Department of Primary Industries

OUT12/30293

22 NOV 2012

Cobbora Coal Project (MP10_0001) Response to exhibition of Environmental Assessment

Figure 5.3A Maximum predicted drawdown in water table aquifer

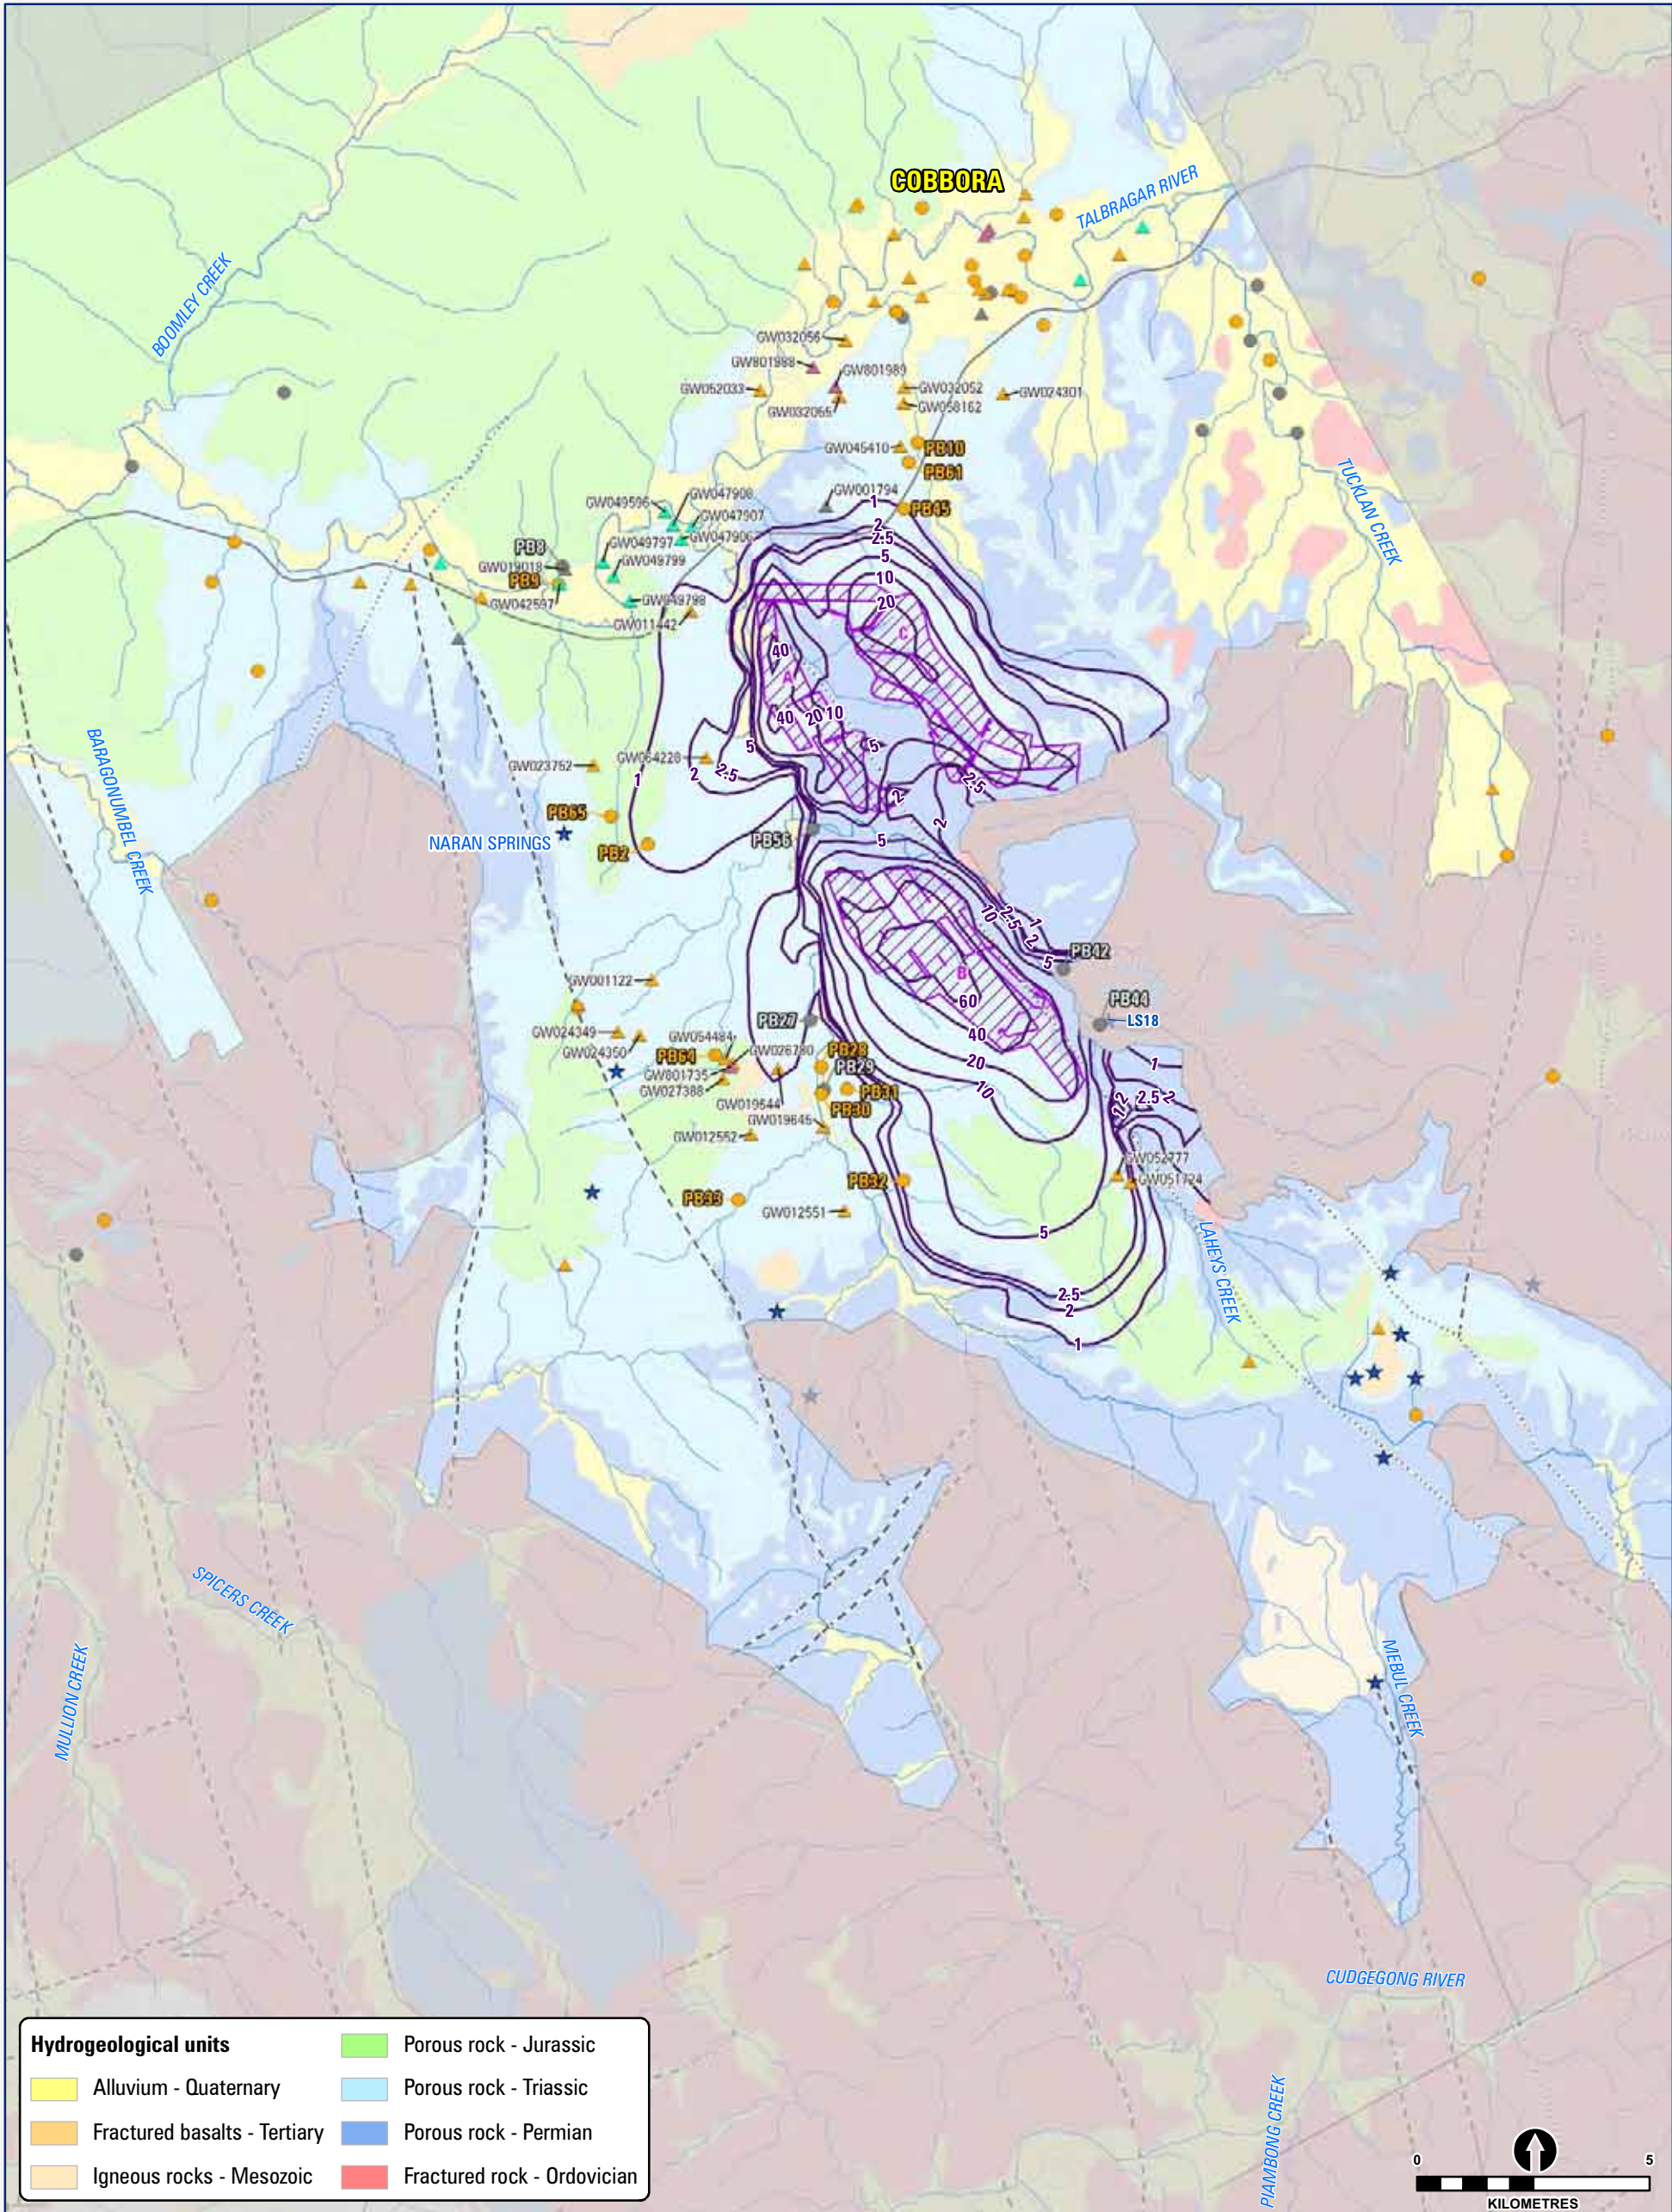
- water table drawdown to be at a maximum near the end of mining with drawdown of more than 1m extending 5km south and 4km west.
 - depressurisation of the Ulan coal seam extends further than the water table impacts with the 1m depressurisation contour extending 5km west of the project.

- The EA has utilised a threshold of 2.5m drawdown at water supply works which identified 6 works to be affected. As the AI policy sets criteria of 2m decline for both water table and pressure at any supply work, the proponent is requested to clarify if additional bores may need to be considered for mitigation options.

Figure 5.7 Predicted groundwater levels 20 years after end of mining

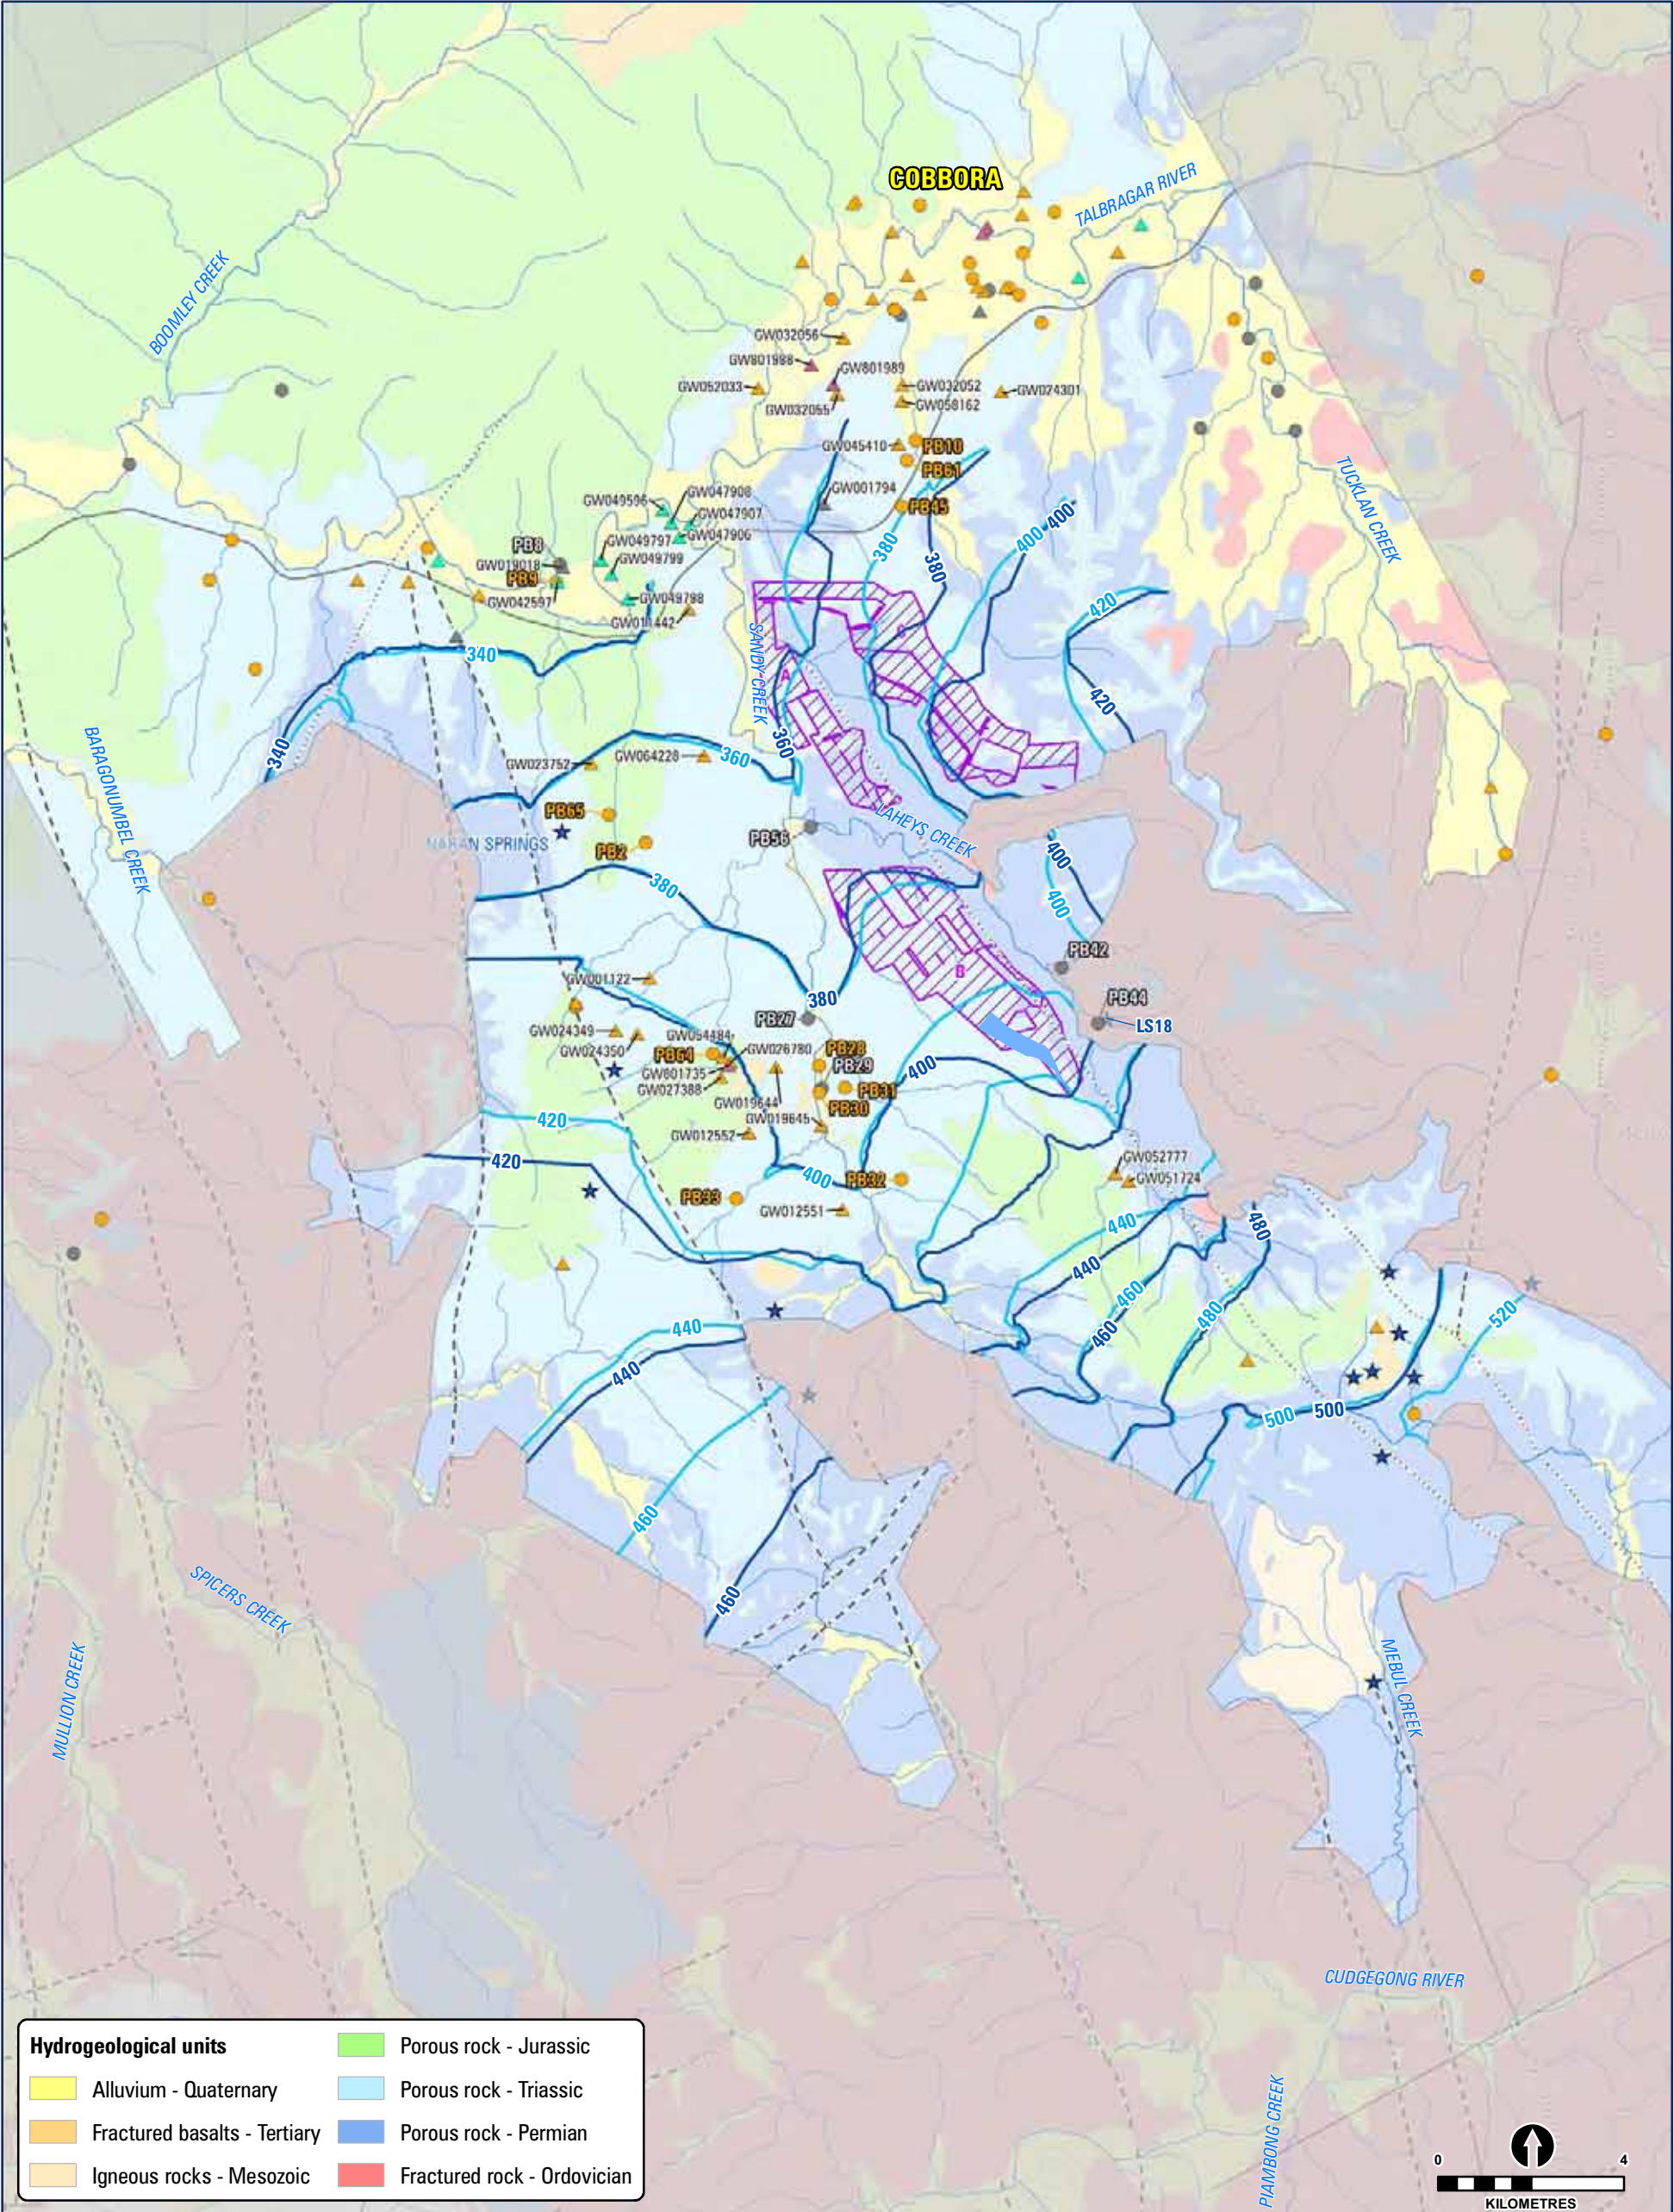
- 20yrs after mining a residual drawdown will remain within 2km of the mining area B void lake. A new equilibrium is to occur 50yrs after mining ceases with some localised drawdown near the void, however the drawdown level is not clearly defined.

- Post closure seepage from the tailings distant from the final void is not likely to be constrained by the local groundwater sink. However the final groundwater contours are not presented at a scale that this can be determined. The Office of Water is concerned with the potential degradation of groundwater and surface water quality and requests further assessment of the impacts and development of mitigating options as required. Detailed groundwater elevation contours in the vicinity of the void lake post mining are requested.
